LANDSCAPE PLAN

LOT 1 - FALCON MARKETPLACE
WOODMEN & MERIDIAN
EL PASO COUNTY, COLORADO

JOB NUMBER	1116-23
REVISIONS	
ORIGINAL DATE	9-15-23
DRAWN BY	
DESCRIPTION	LANDSCAPE PLAN
SHEET NO.	L1.1

LANDSCAPE PLAN - AREA 'A'

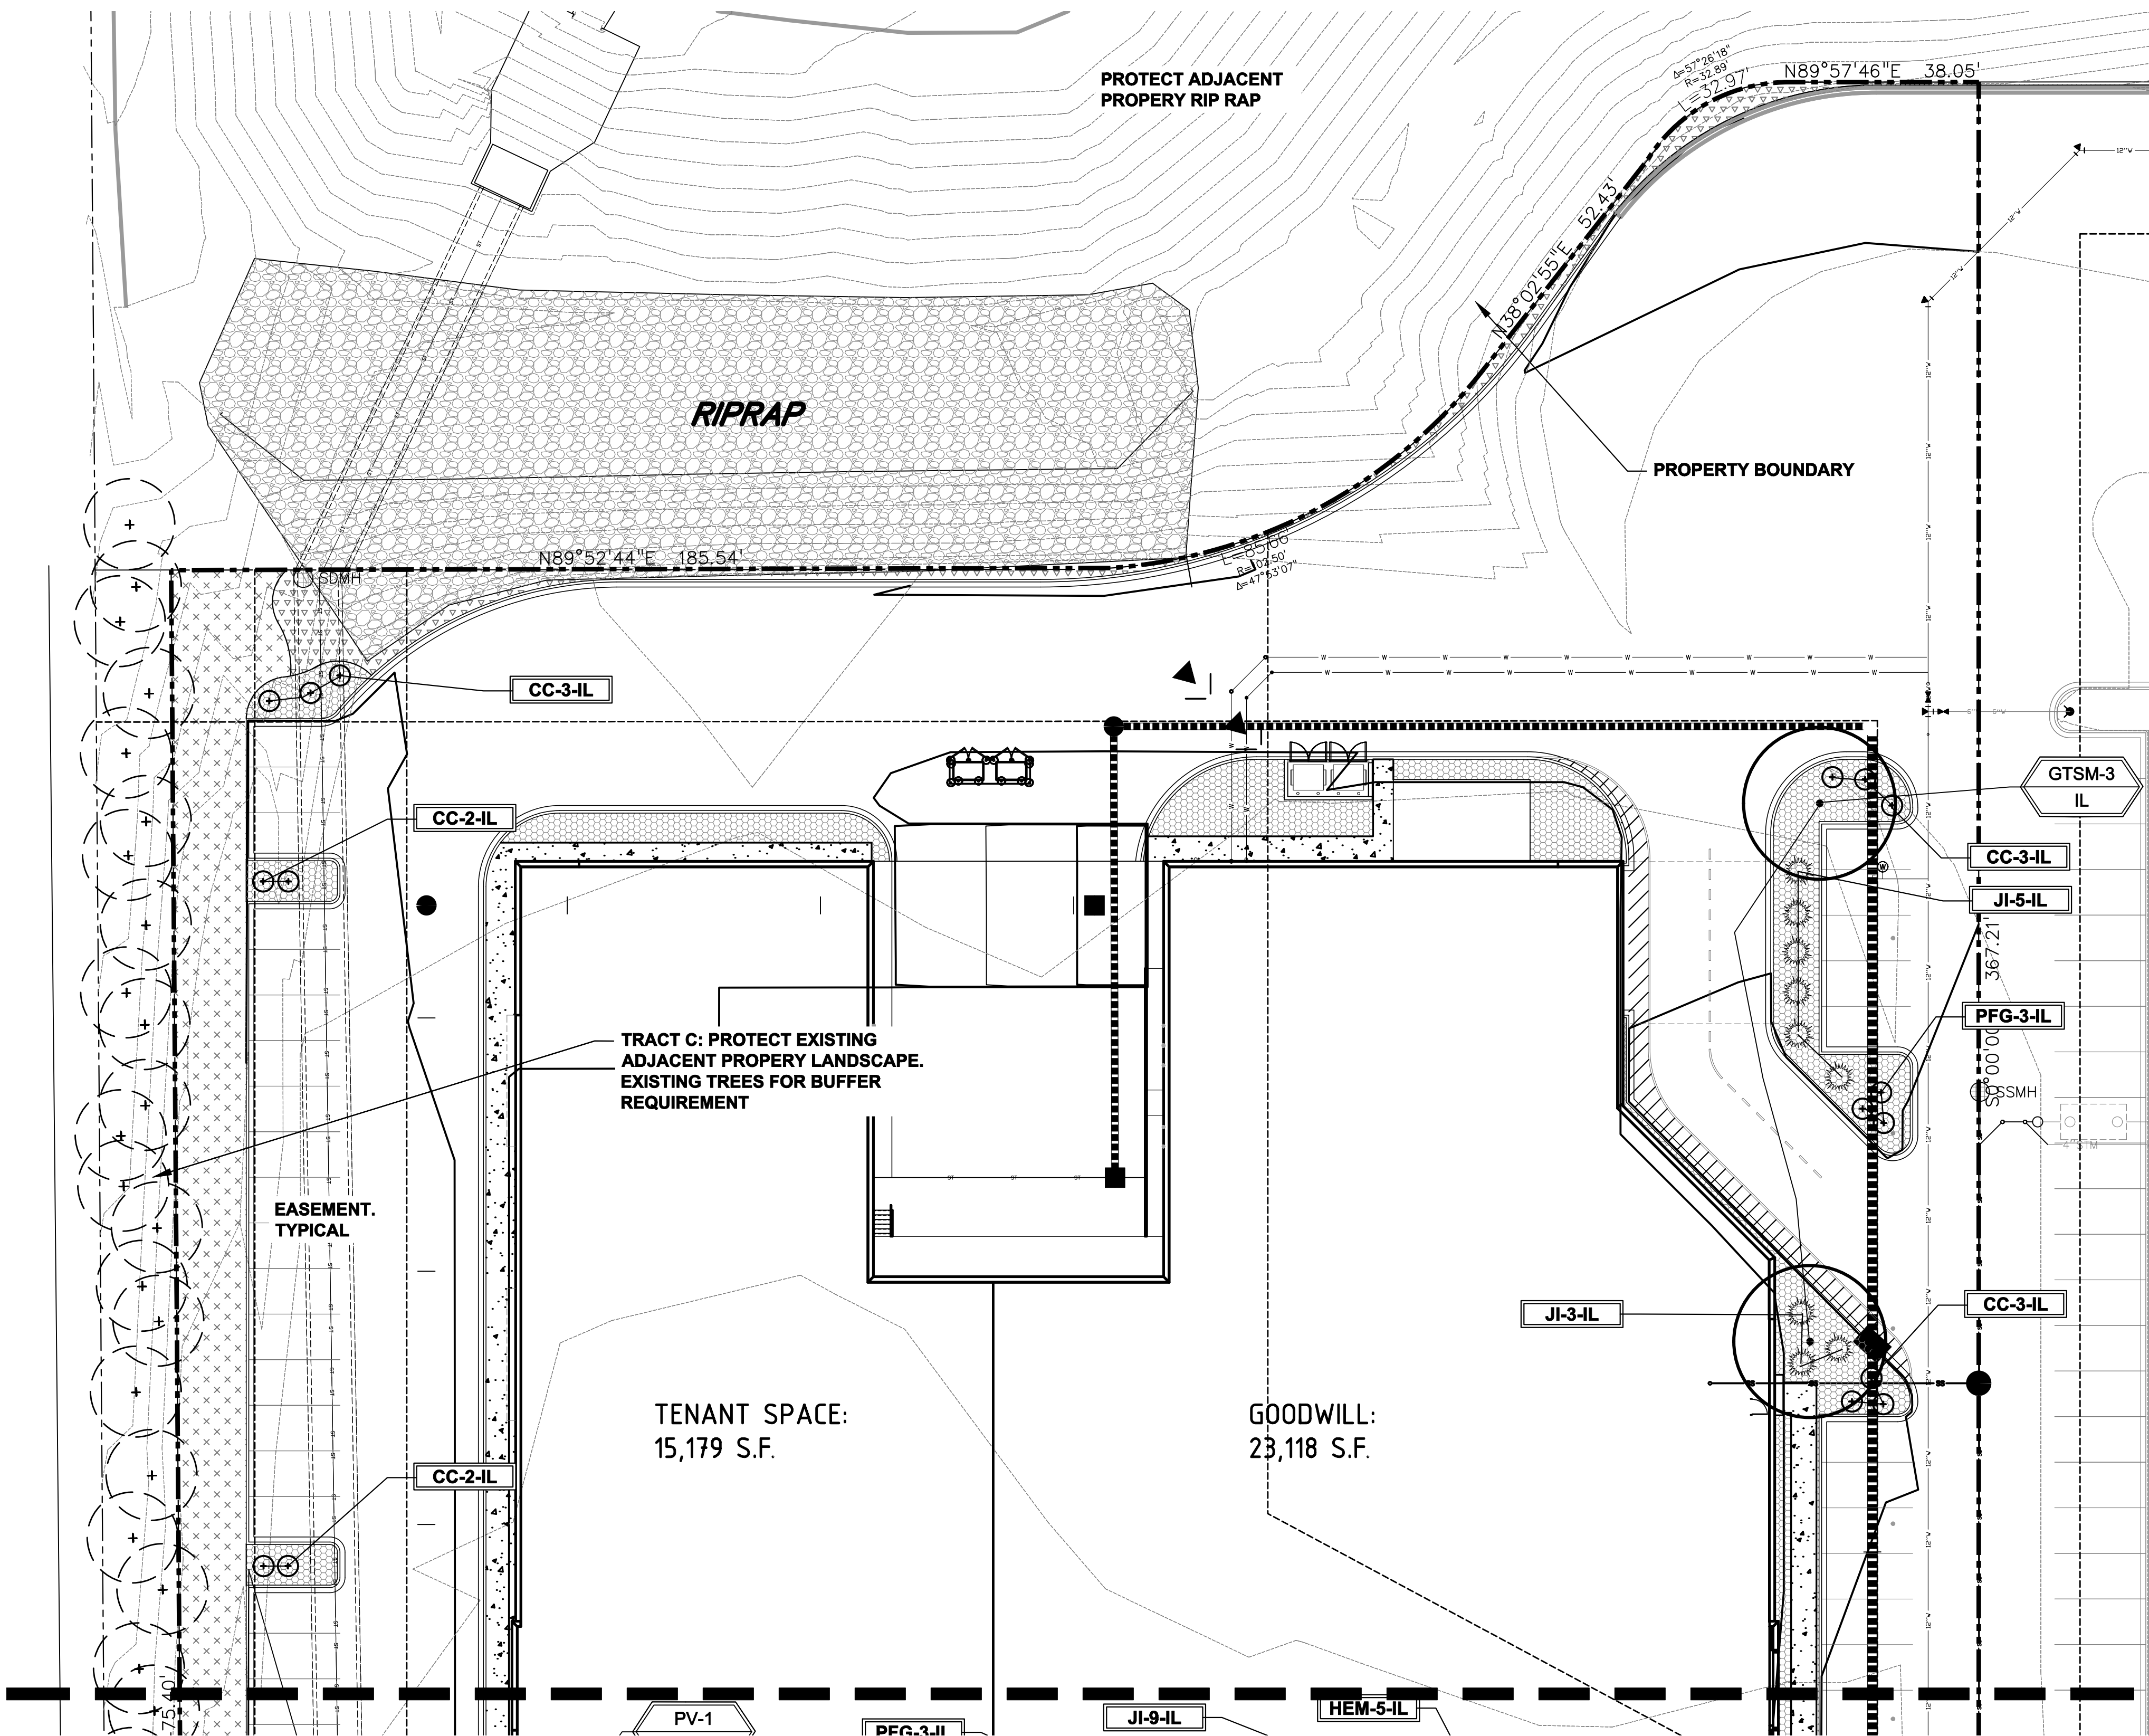
- location and dimensions of all property lines, rights of way, and all existing easements on pages 2 and 3
- Zoning of Property (CR)
- Address comments on page 2

Include owner name, ph. # and email

Show Quantity of each plant type
